THE COTTAGES AT MESA RIDGE GOODWIN KNIGHT EL PASO COUNTY, COLORADO

NOT FOR CONSTRUCTION SHEET L.01 1 PUD DEVELOPMENT PLAN LANDSCAPE COVER SHEET

Landscape Plan drawings_V1 redlines.pdf Markup Summary

SHEET
 L.07

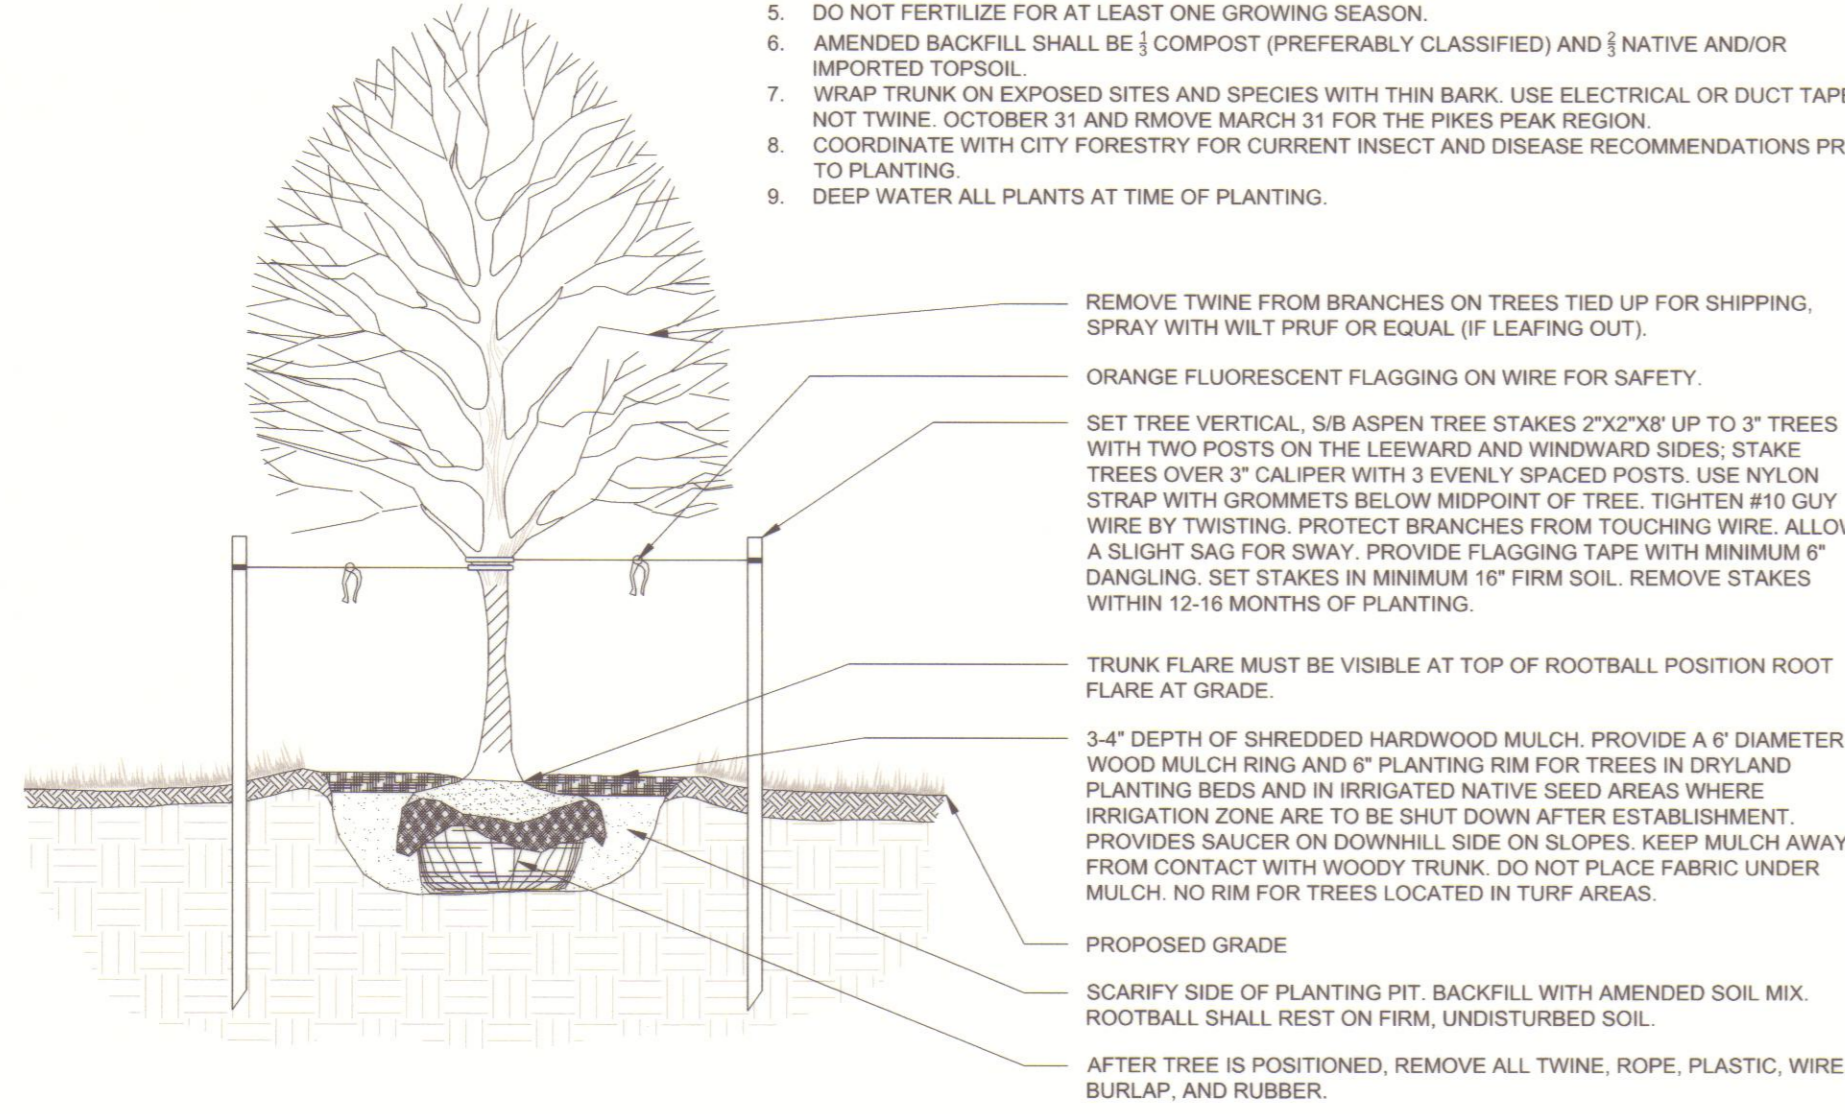
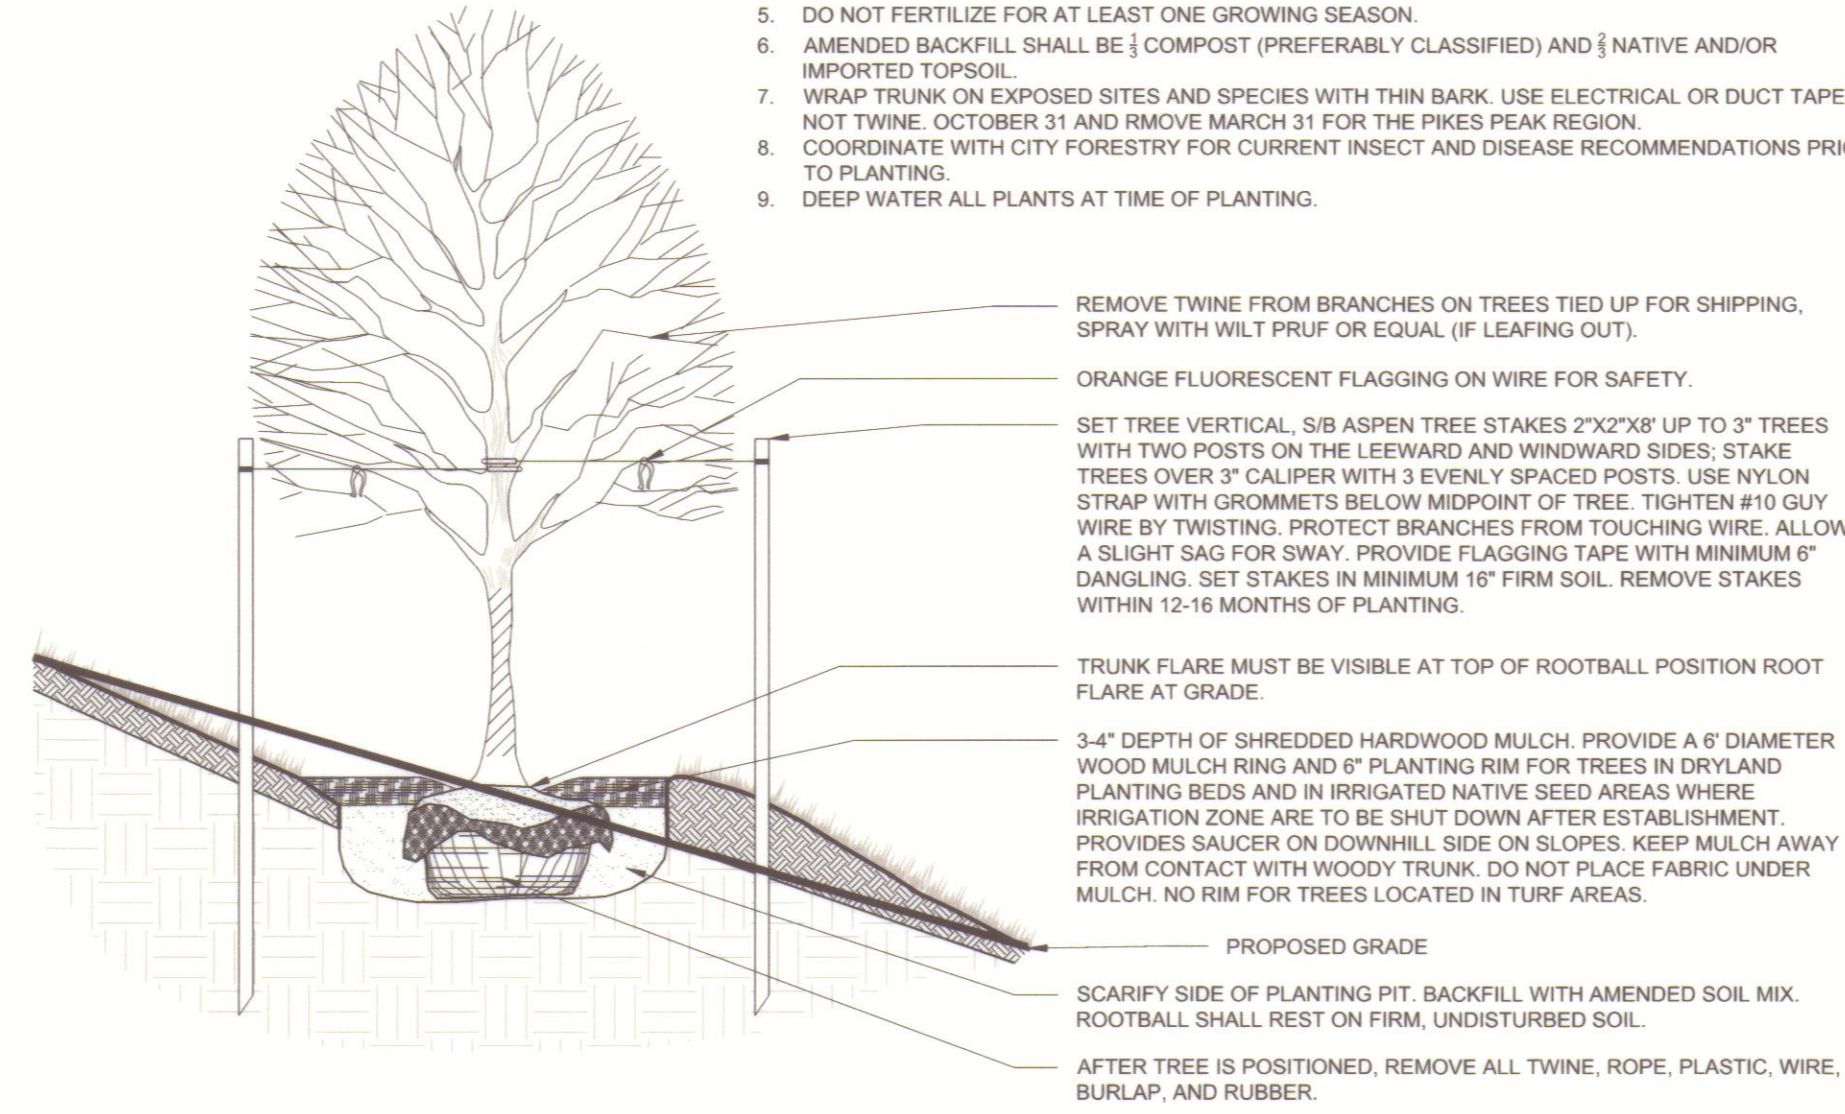
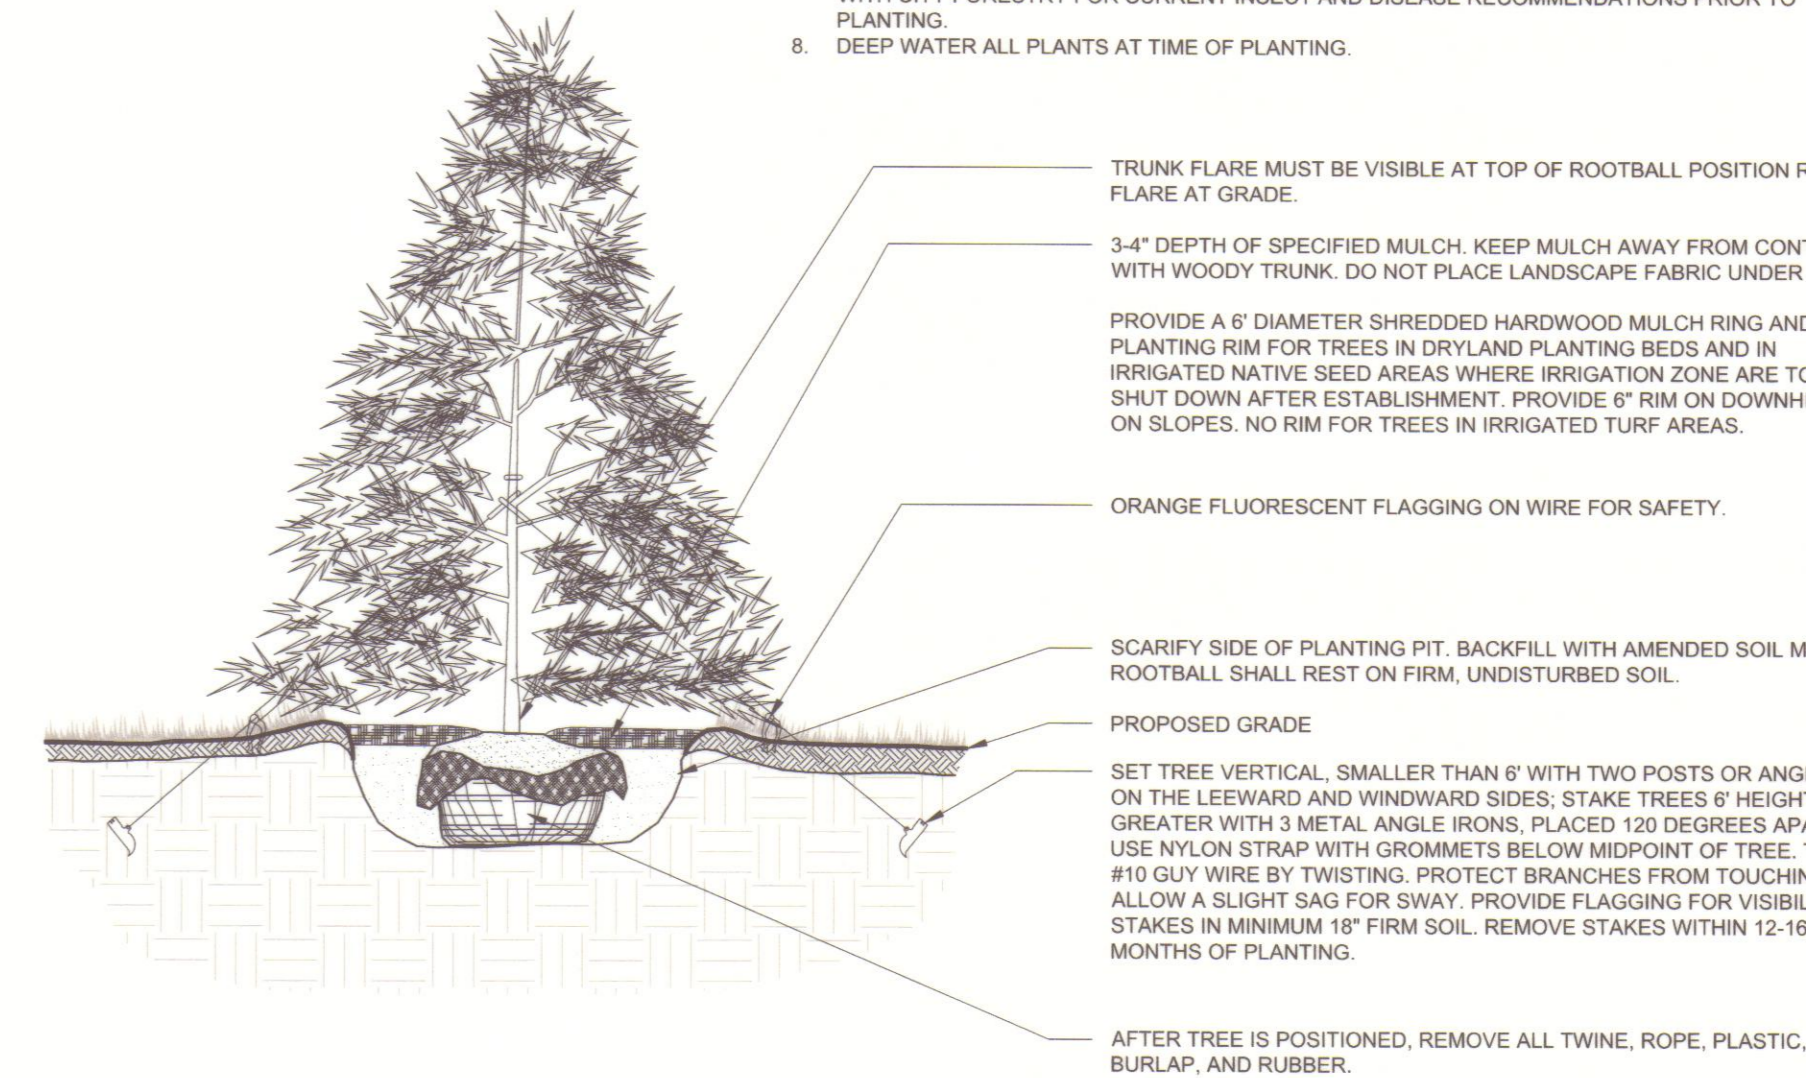
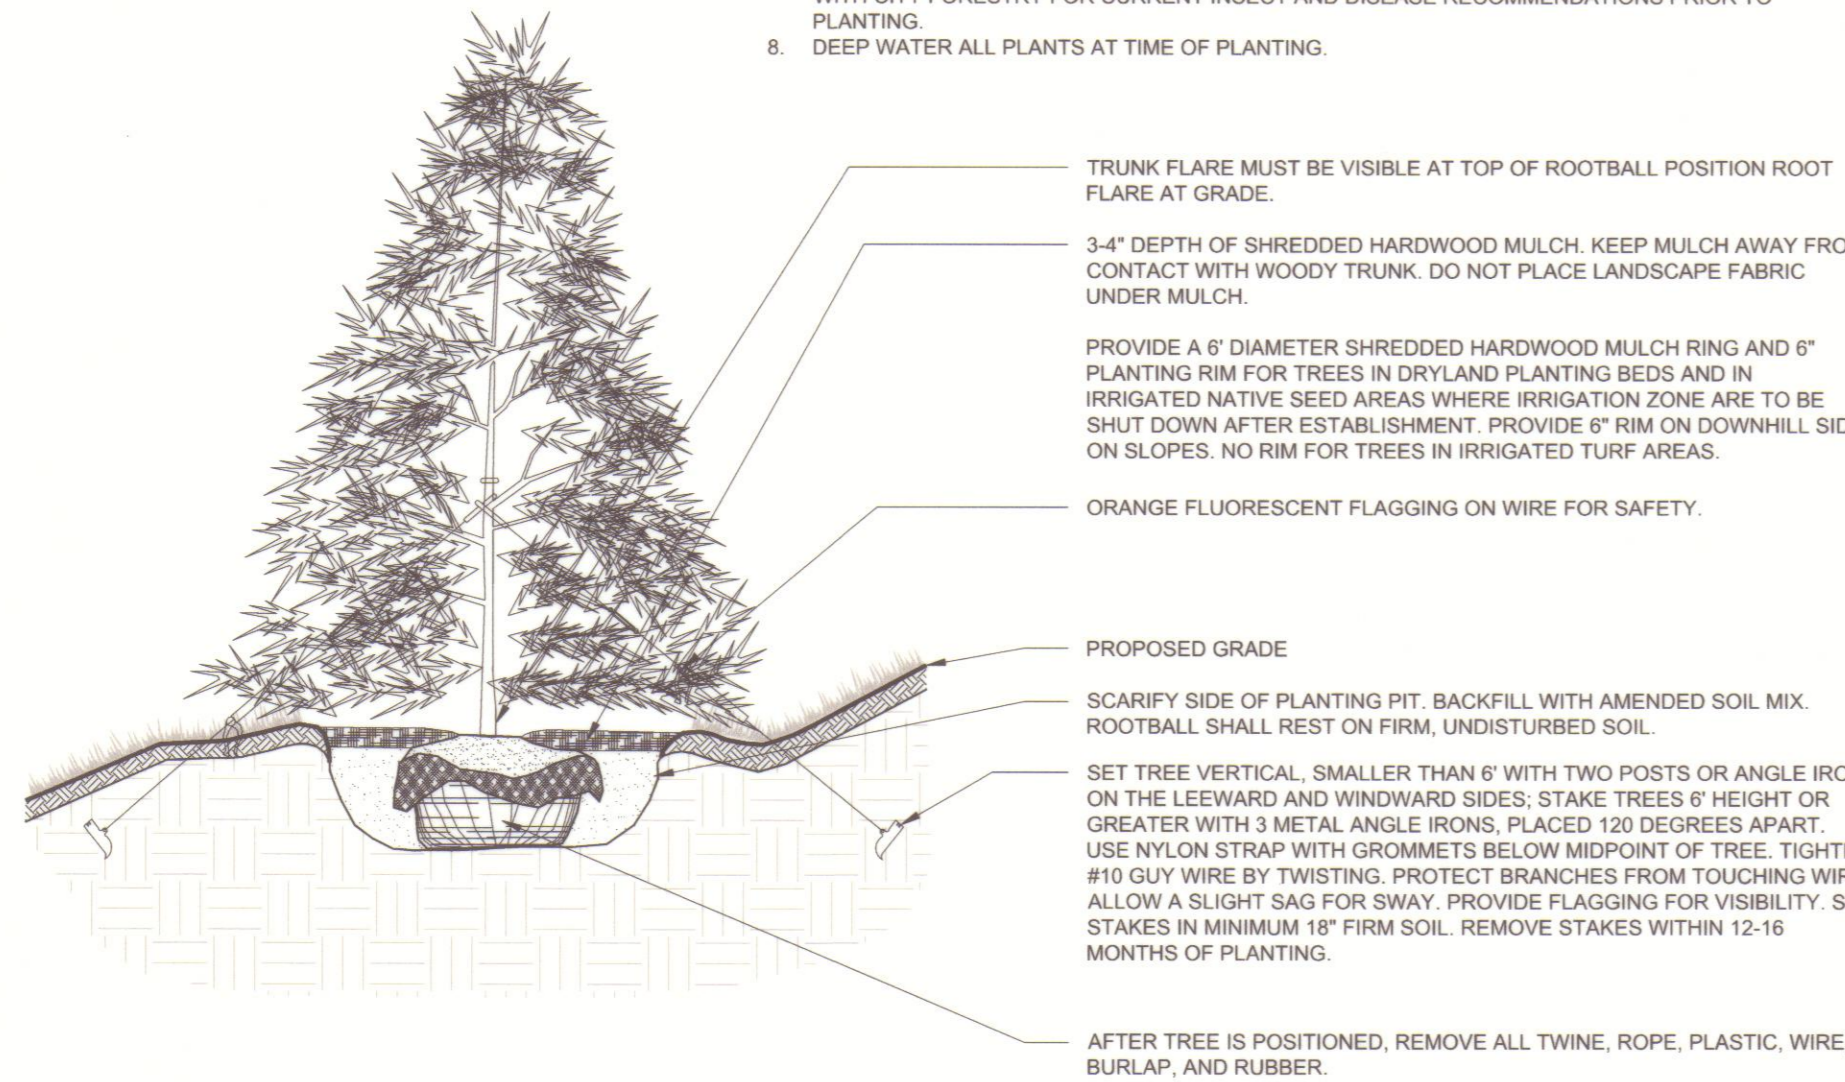
planting details; fencing details;
